**Consultation Response from Mike Hibbert,
KC Waste Strategy(Refuse & Recycling)**

2023/90668 Grange Moor Coachworks, Barnsley Road, Grange Moor, Huddersfield, WF4 4DR

Erection of B2/B8 Industrial Unit and associated works

Date Responded: 16/03/2023.

Drawing No: P2753-ACU-XX-DR-A-102-01 Rev No:

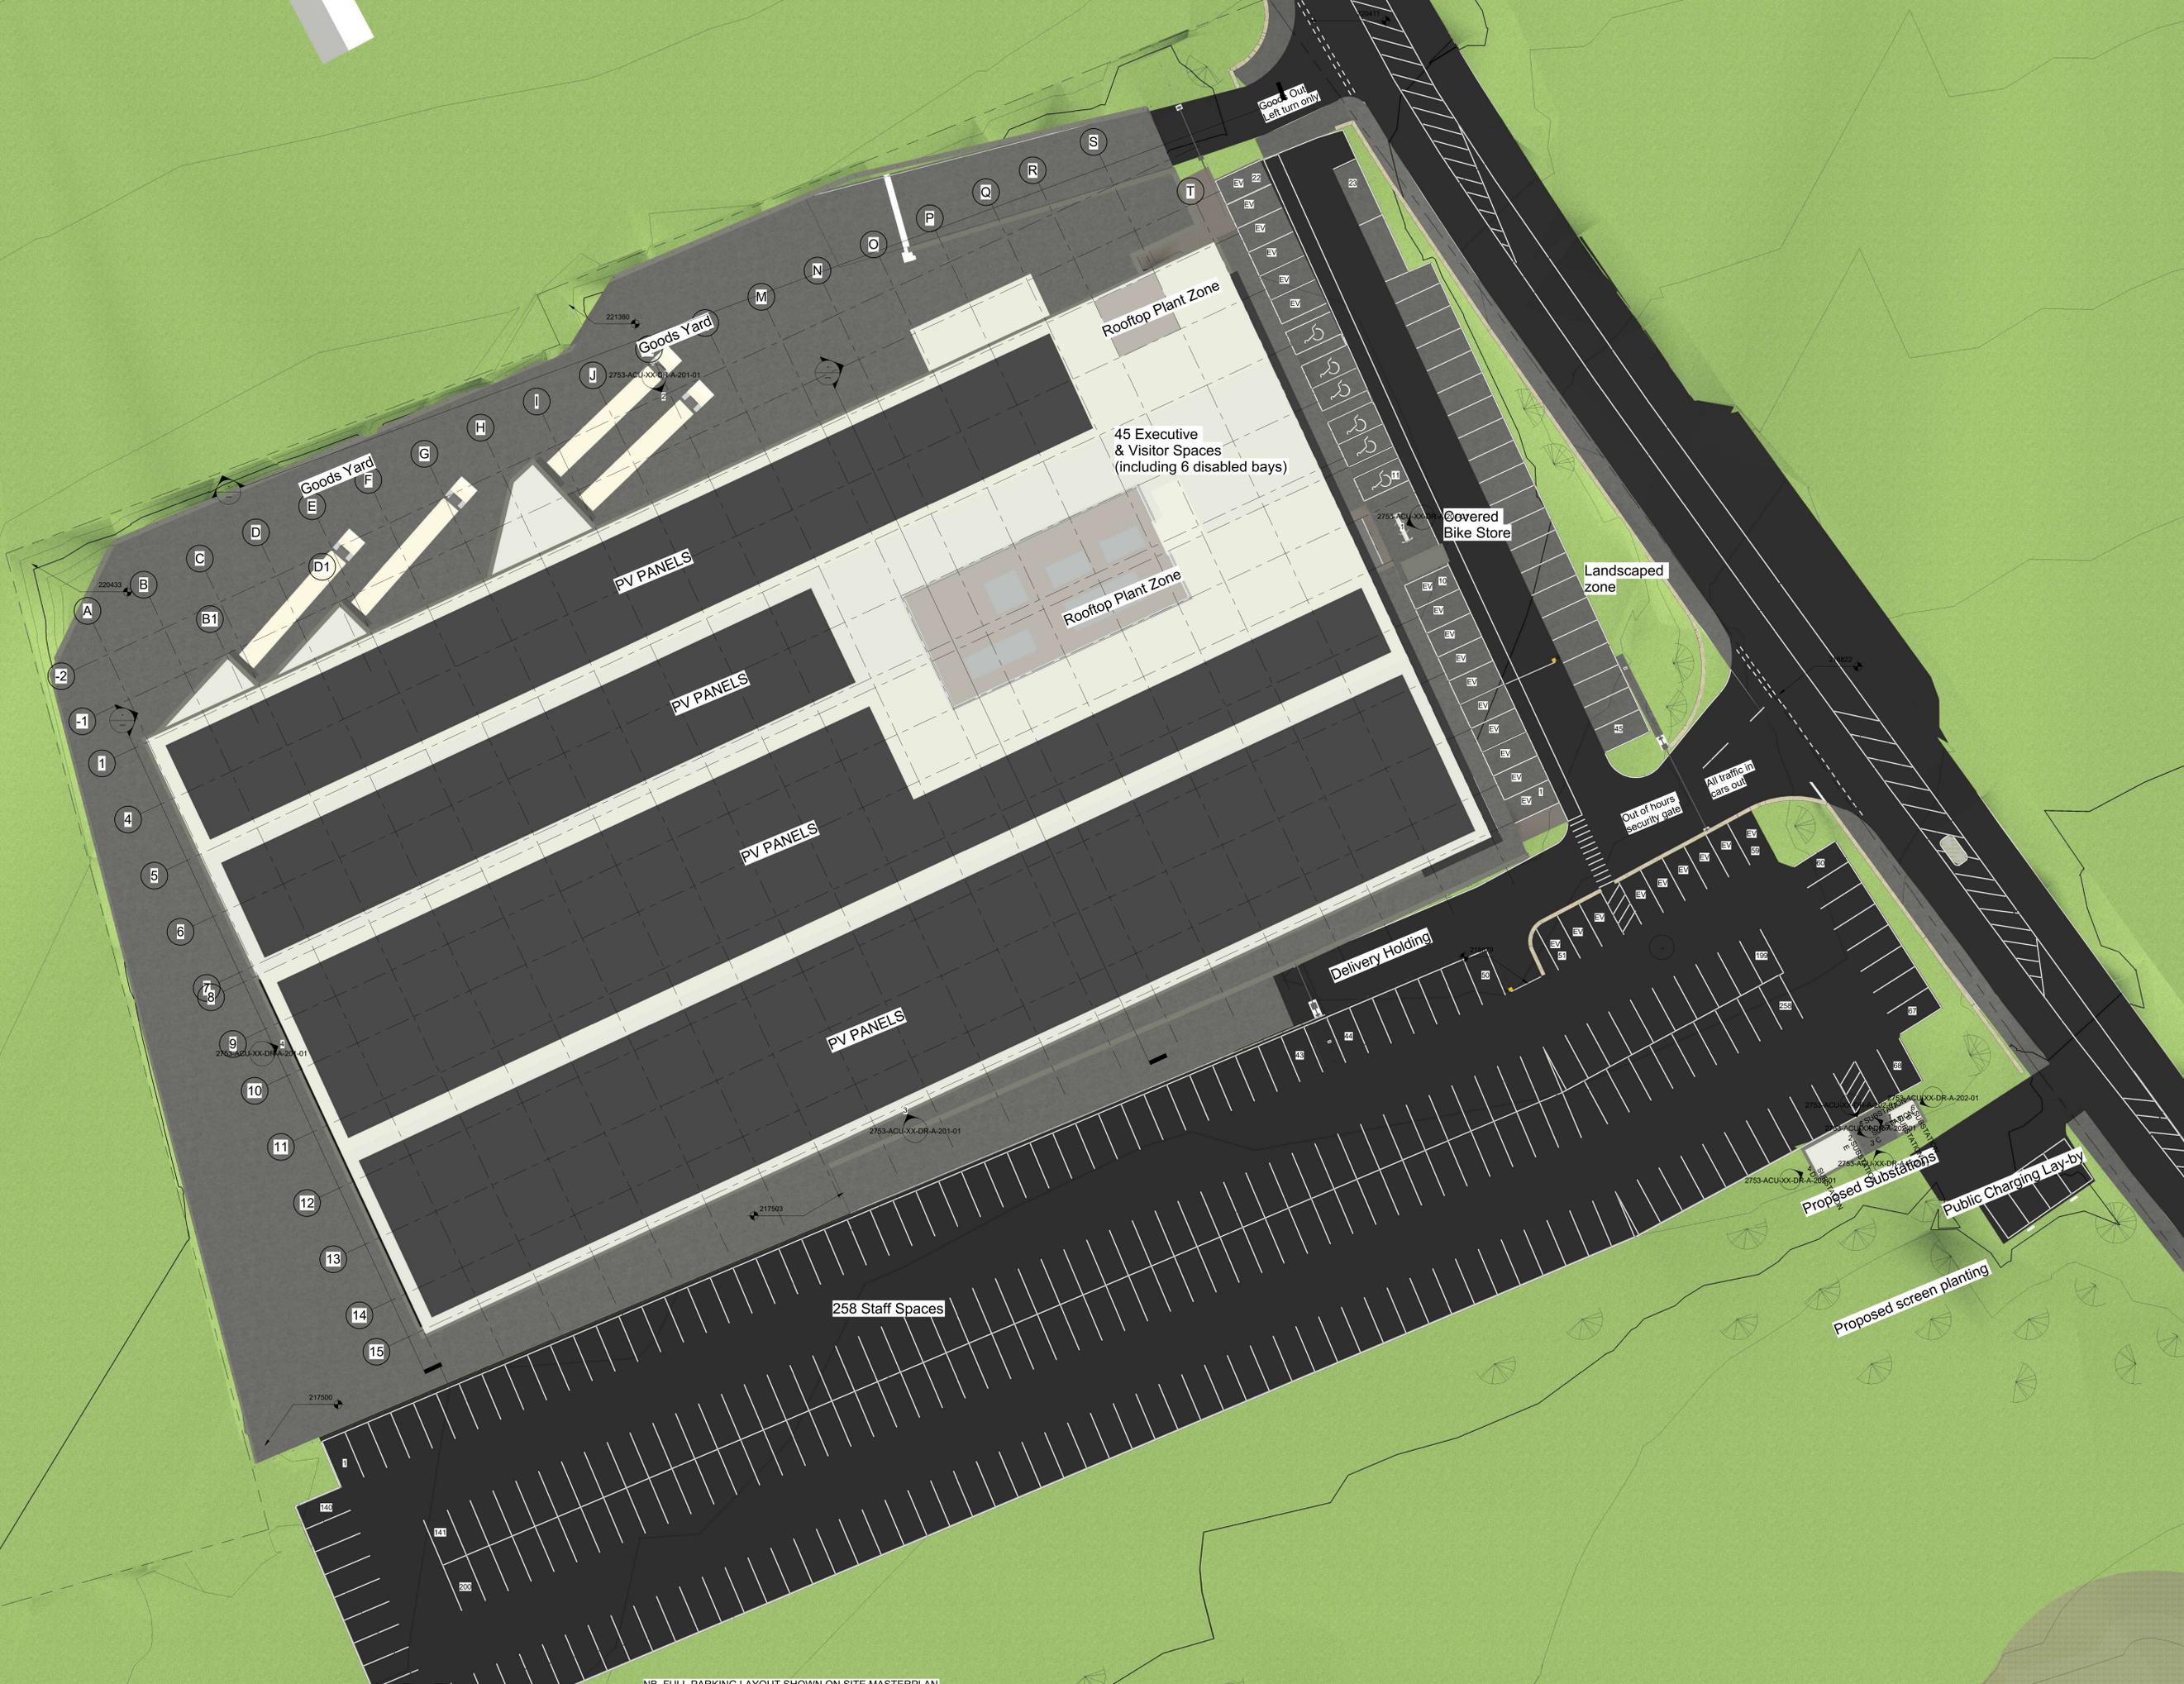
The application form, in the Waste Storage and Collection section, states Bin Storage and Collection points provided. The application includes PROPOSED MASTERPLAN P2753-ACU-XX-DR-A-102-01 FEB'23 that shows a 48m² Waste storage area on the Northern side of the warehouse.

- With limited information included in the application it is therefore difficult to predict likely waste generation and therefore waste storage capacity required. As the applicant has two existing operational facilities at Grange Moor waste arisings data should be available and there will be existing provision for waste generated at those sites. If not using skips, the drag out distance for wheeliebins from a Bin store/ premises to the collection vehicle should preferably be under 15m. Any waste storage area should be secure to prevent theft, unauthorised use/ fly tipping, arson or rough sleeping.

- Waste storage presents a fire risk. Any skip/ wheeliebin storage location should be carefully considered when undertaking a fire risk assessment and may need relocating away from buildings.

- In line with Government's OUR WASTE, OUR RESOURCES: A STRATEGY FOR ENGLAND and the requirement for waste producers to comply with Regulation 12 of The Waste (England and Wales) Regulations 2011 there should be separate provision for recyclates and residual wastes. Waste storage should be identified on site either internally or on the service yard to accommodate general waste and packaging/ cardboard skips. As the facility includes a canteen/ employee rest area then there should be thought to arranging separate collection of food waste and Dry Mixed Recyclables.

- Any waste storage compounds should be large enough to accommodate the waste being stored and constructed with an impermeable floor surface. Specification and guidance can be found in the [Waste Management Design Guide for New Developments \(kirklees.gov.uk\)](https://www.kirklees.gov.uk)
